To: All Staff
From: Environmental Health
Date: April 29, 2026
Subject: BL-26-00004 Central WA Land Group

EXHIBIT 4 ADJUSTED PARCELS

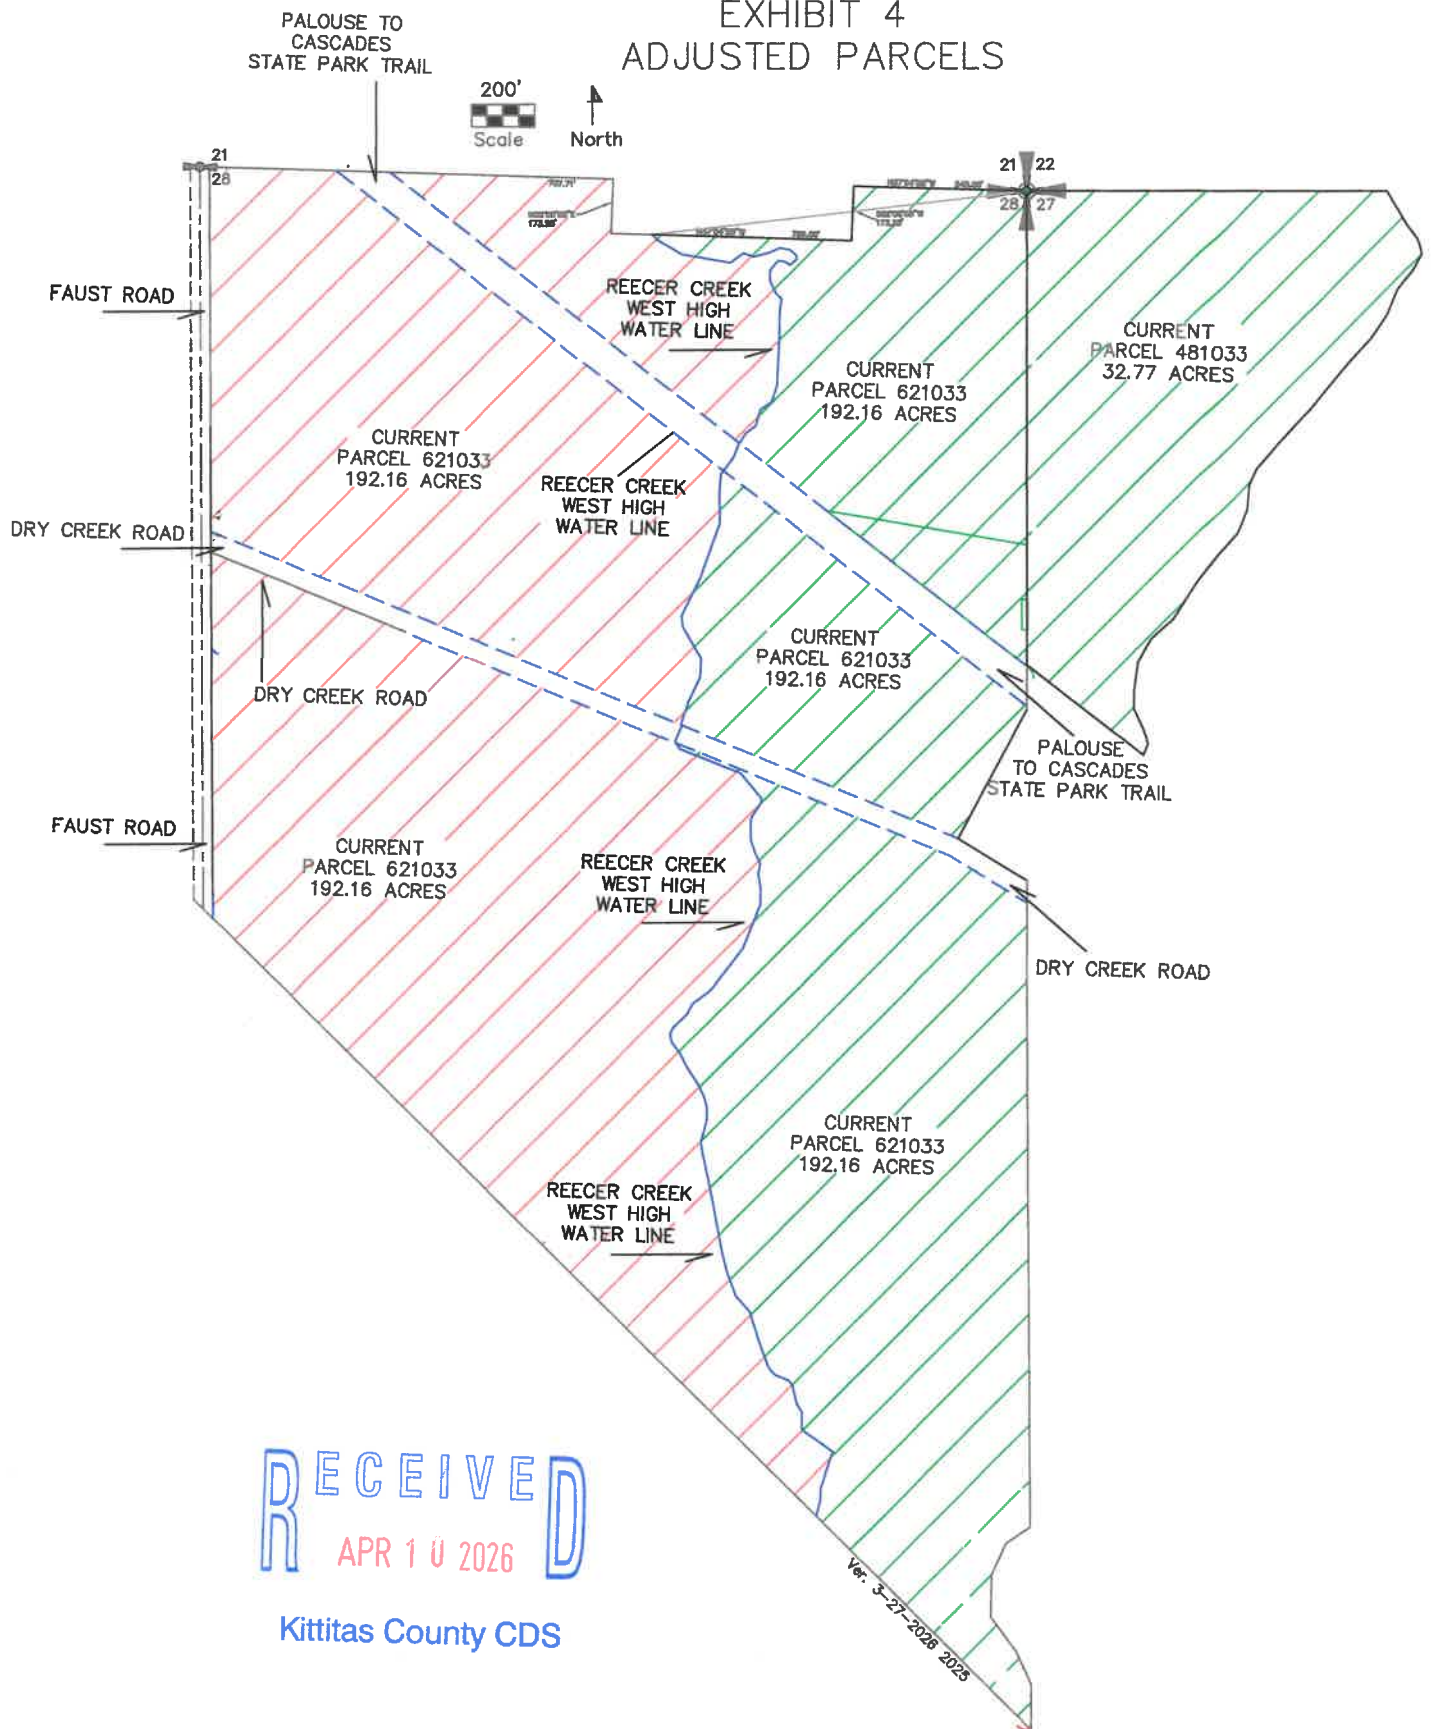
Drinking Water	<ul style="list-style-type: none">• For any boundary lines in proximity to wells, please ensure that wells are not relocated within 50 feet of property lines
Wastewater	<ul style="list-style-type: none">• Please confirm that all septic systems are located at or beyond the minimum proposed setback distances from property lines, and that any abandoned septic systems will be appropriately decommissioned by filling or removal
